2024/0673

Address: 4 Old manor drive, Oxspring, Barnsley S36 8ZY

Description: Removal of front door canopy, and erection of new front porch and canopy (retrospective)

org title
Existing & Proposed Floorplans, Elevations & Site Plan

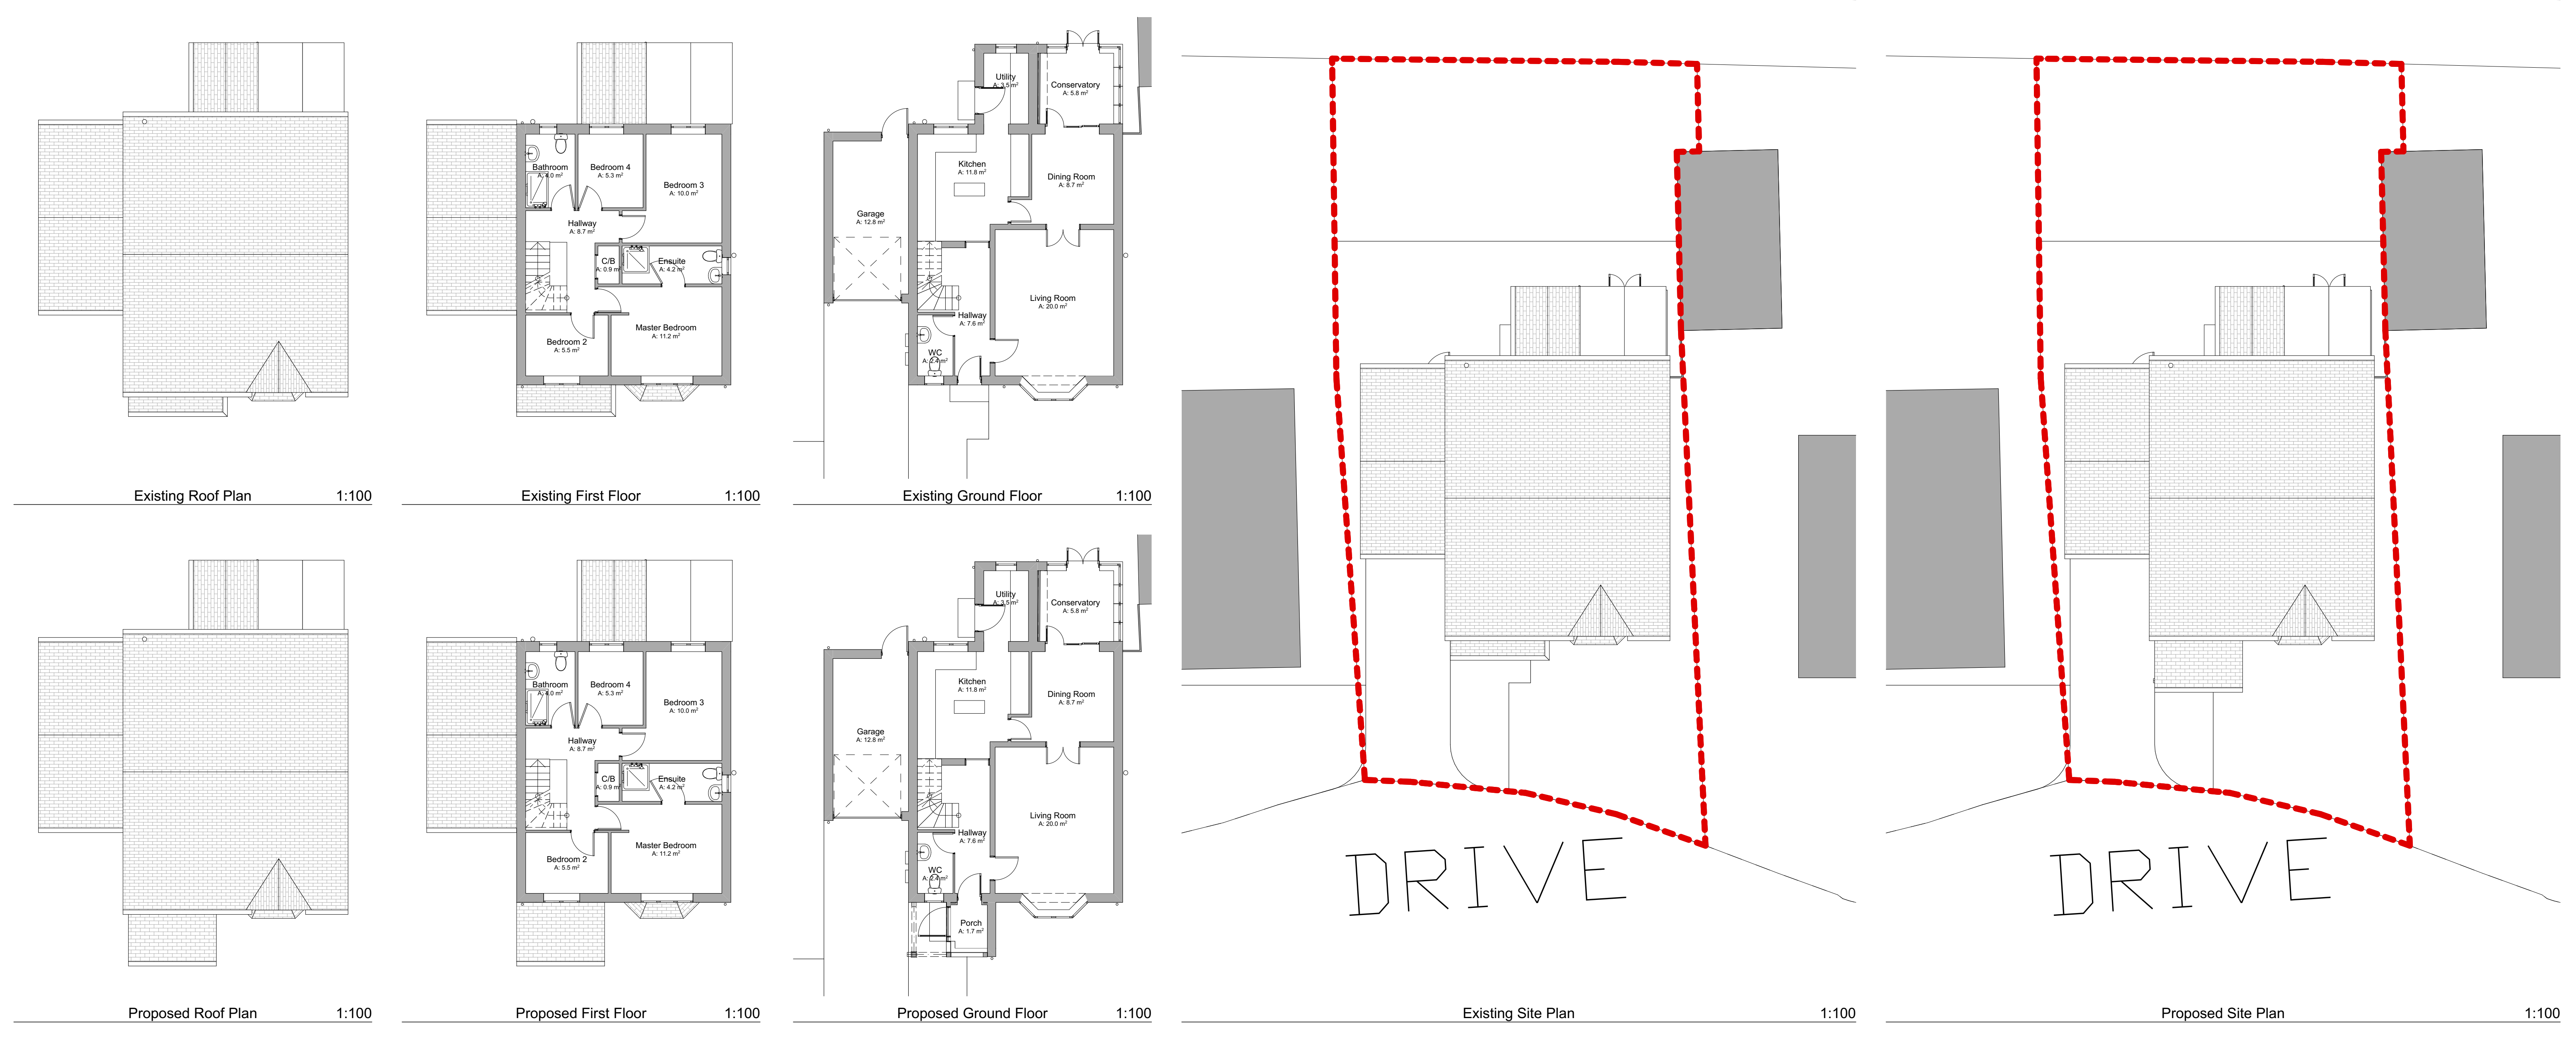
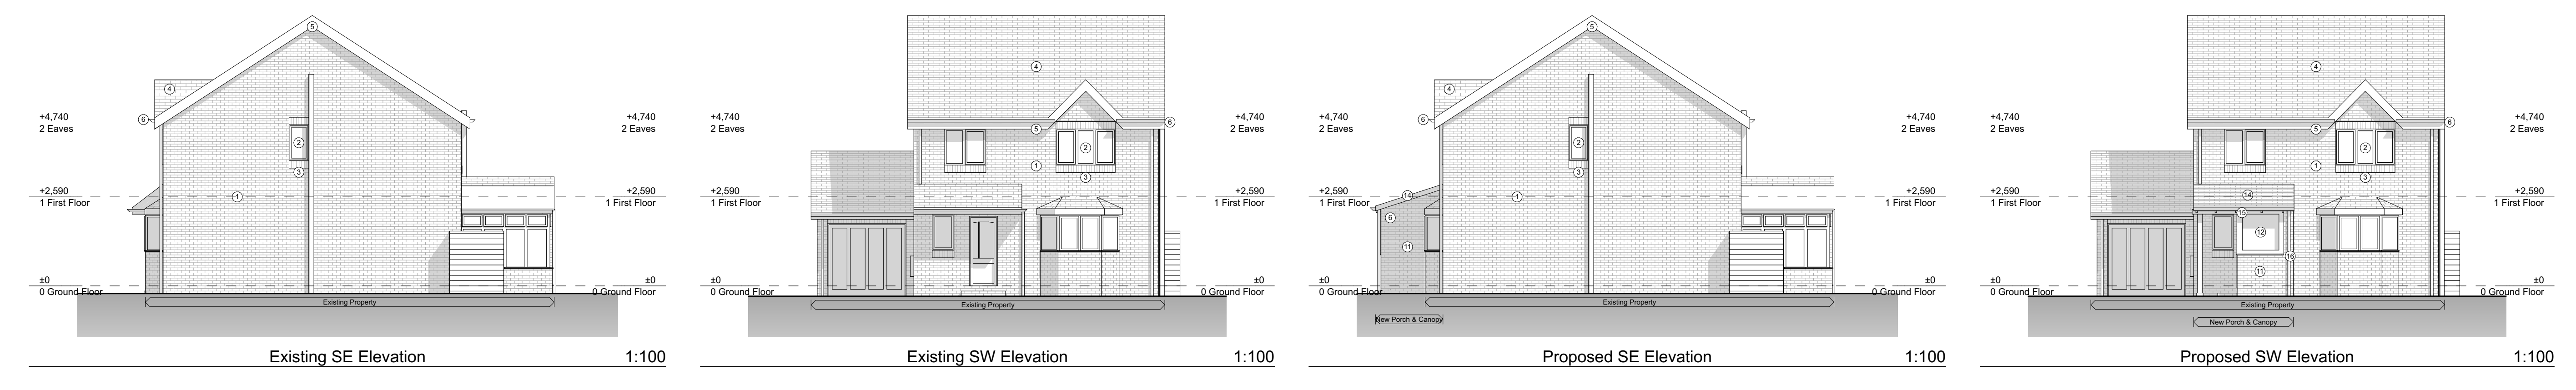
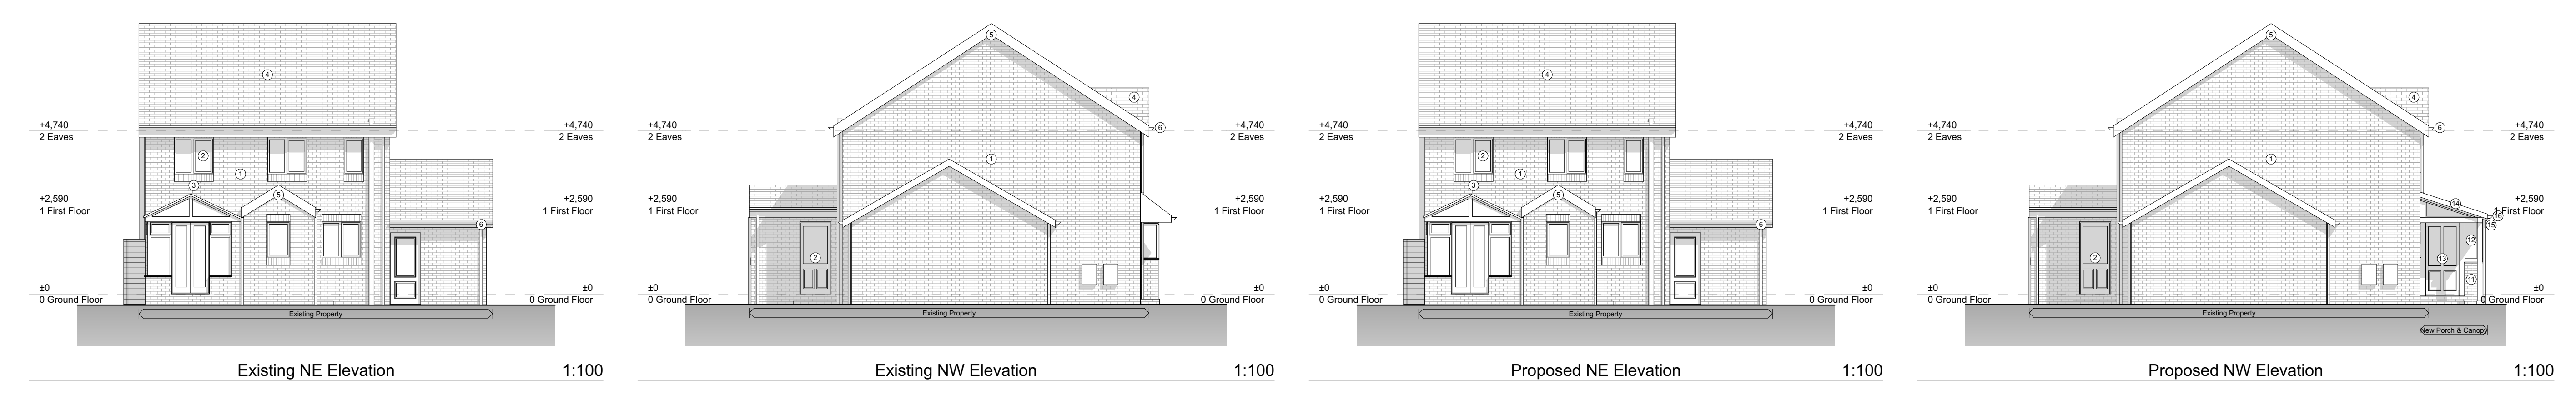
There is no concern over the structure of the porch and canopy, which although larger than allowed through permitted development, is of a modest size and does not cause any noticeable negative impact to the original dwelling, nor that of the broader street scene. However, the current colour of the wood, visible as a feature of the structure, would not be a suitable colour and would harm the character of the dwelling and more concerningly the broader character of the street scene.

Following an initial request for the porch to be stained or painted in a colour to match the existing windows, it was advised that the existing windows are proposed to be replaced, which is allowable without planning consent. A suggested colour of Oak (medium brown) for the porch has been proposed, which is lighter than the existing windows, but would match the proposed window colour. To allow some flexibility in the colour choice of the porch, but to maintain an acceptable colour, a condition of the planning consent would allow the porch to be stained or painted in the proposed colour of Oak or the colour of the proposed windows, Golden Oak (grained), both of which have been confirmed on a colour chart image. The condition would also require completion of this work within two months from the date of the decision notice's issuance. In view of this the visual impact of the proposal is considered acceptable.
